**GEOTECHNICAL UNIT FIELD SCOUR REPORT**

PROJECT: 8.2572401 TIP NO.: B-3506 COUNTY: RANDOLPH

DESCRIPTION(1): BRIDGE NO. 226 ON SR 2832 OVER RICHLAND CREEK

GENERAL DRAWING
 FOR BRIDGE OVER
 RICHLAND CREEK ON
 SR 2832 BETWEEN
 SR 2845 AND NC 42

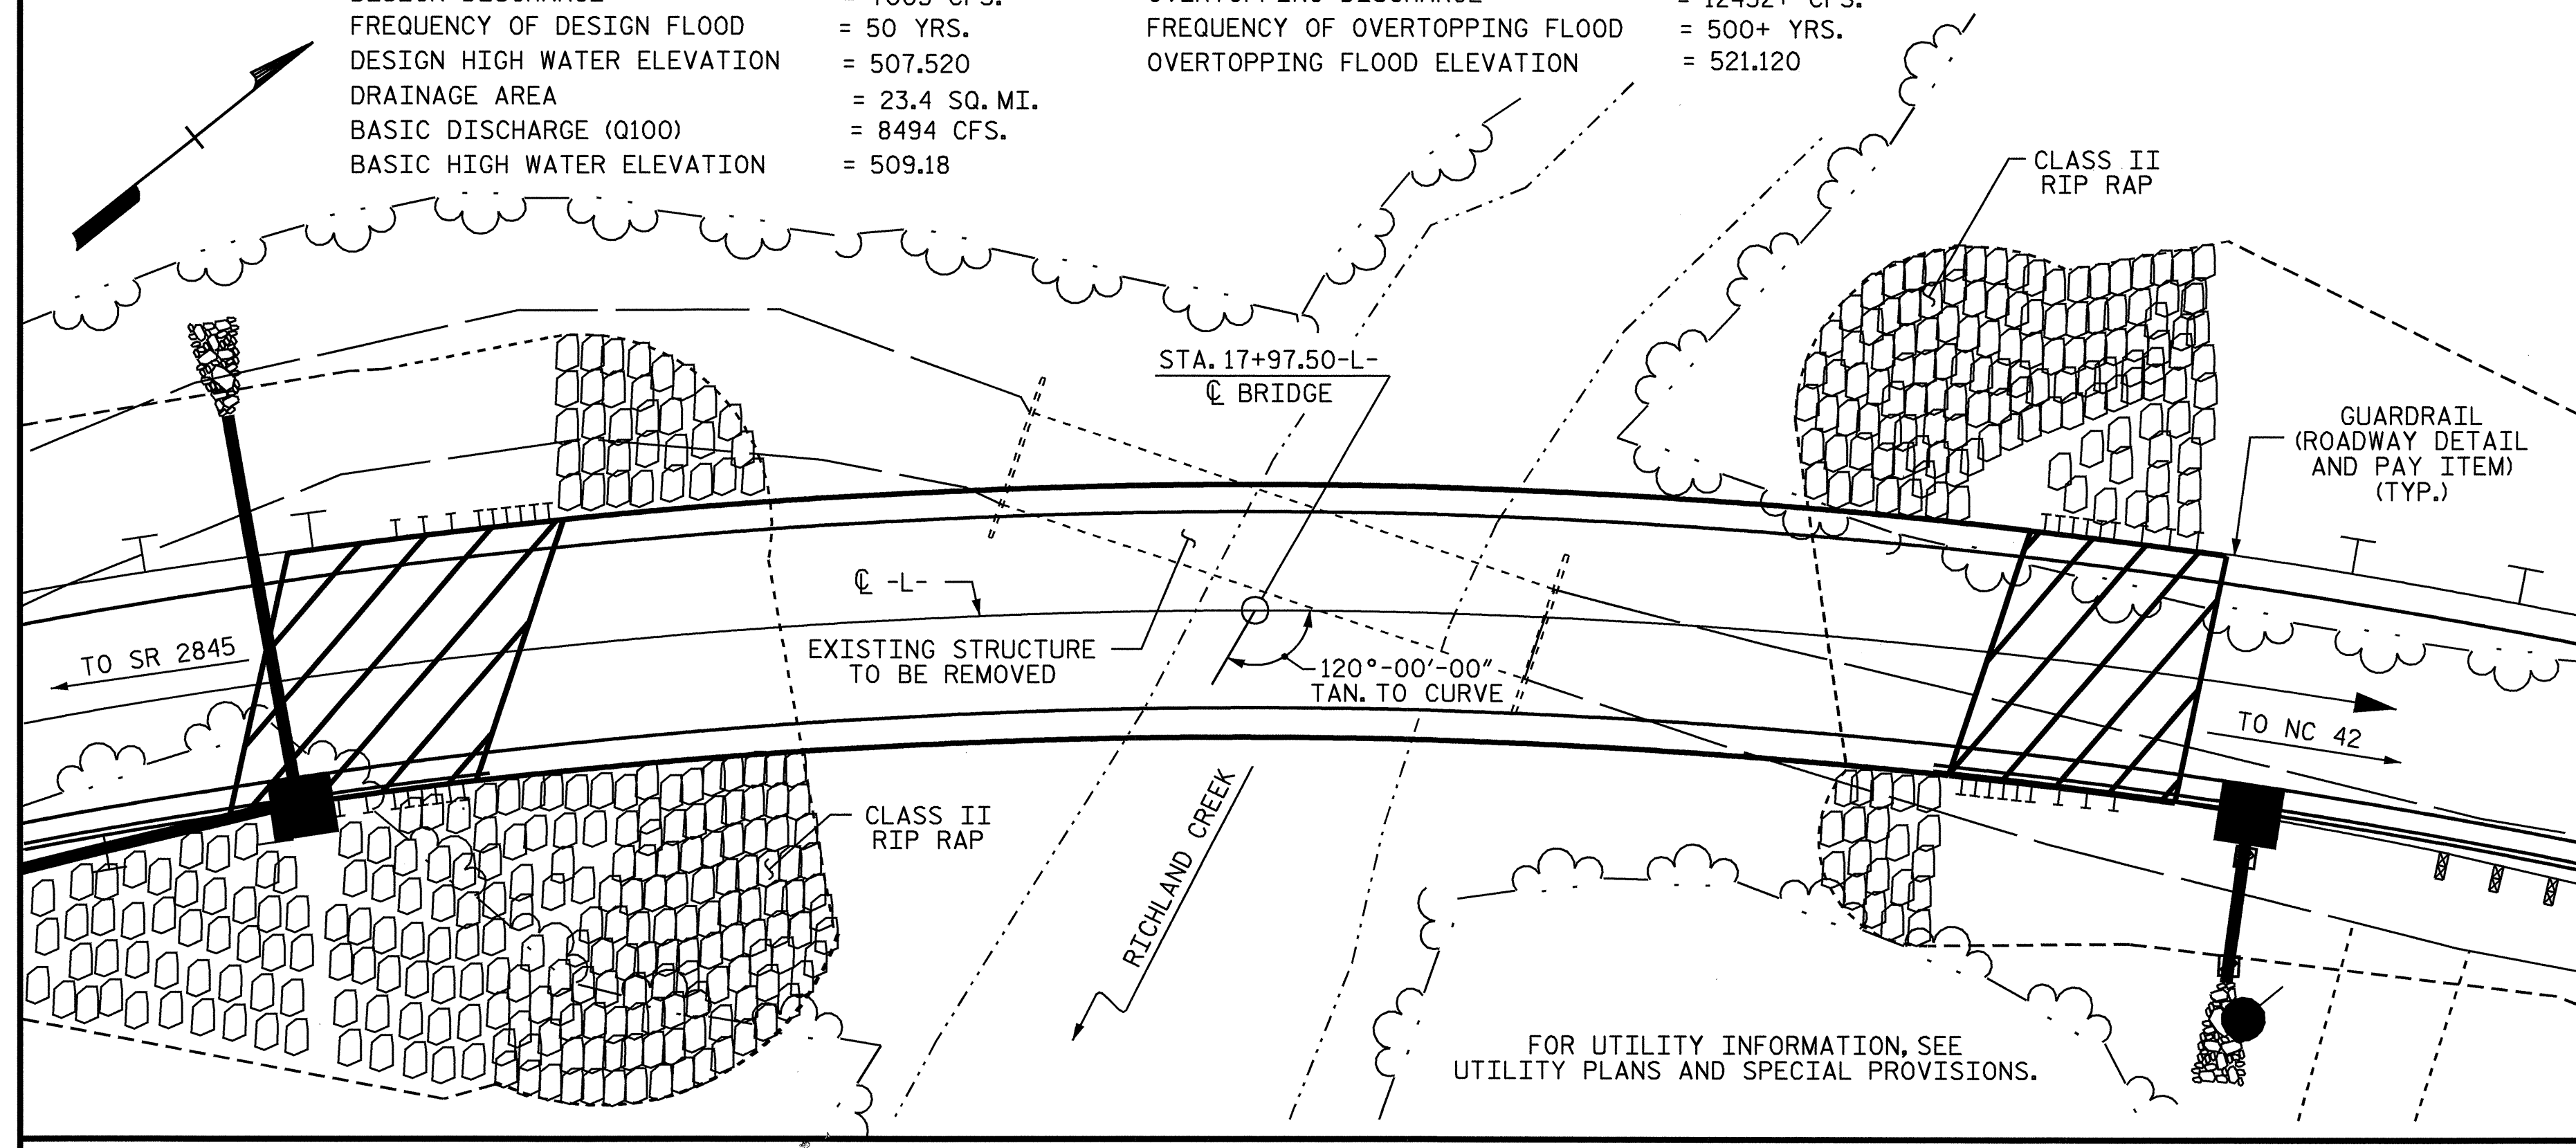
THE GEOTECHNICAL ENGINEERING UNIT HAS REVIEWED THE SCOUR DATA PROVIDED BY THE NCDOT BRIDGE SURVEY AND HYDRAULICS DESIGN REPORT. IN DOING SO WE HAVE CONCLUDED THAT BOTH 100 AND 500 YEAR SCOUR COMPUTATIONS SHOULD BE RAISED SIGNIFICANTLY TO COINCIDE WITH THE OCCURRENCE OF HARD ROCK. THE CREEK BOTTOM ITSELF IS RUNNING ON HARD ROCK.

AT PROPOSED INTERIOR BENT 1 HARD ROCK WAS ENCOUNTERED AT THE GROUND SURFACE AND APPEARS TO CONTINUE ACROSS THE BENT AT APPROXIMATE ELEVATION 496.0 FEET.

PROPOSED INTERIOR BENT 2 FALLS WELL OUTSIDE THE CREEK CHANNEL THEREFORE THERE SHOULD BE NO POTENTIAL FOR SCOUR. IT SHOULD HOWEVER BE NOTED THAT HARD ROCK WAS ENCOUNTERED BETWEEN ELEVATION 497 - 502 FEET AT THIS LOCATION.
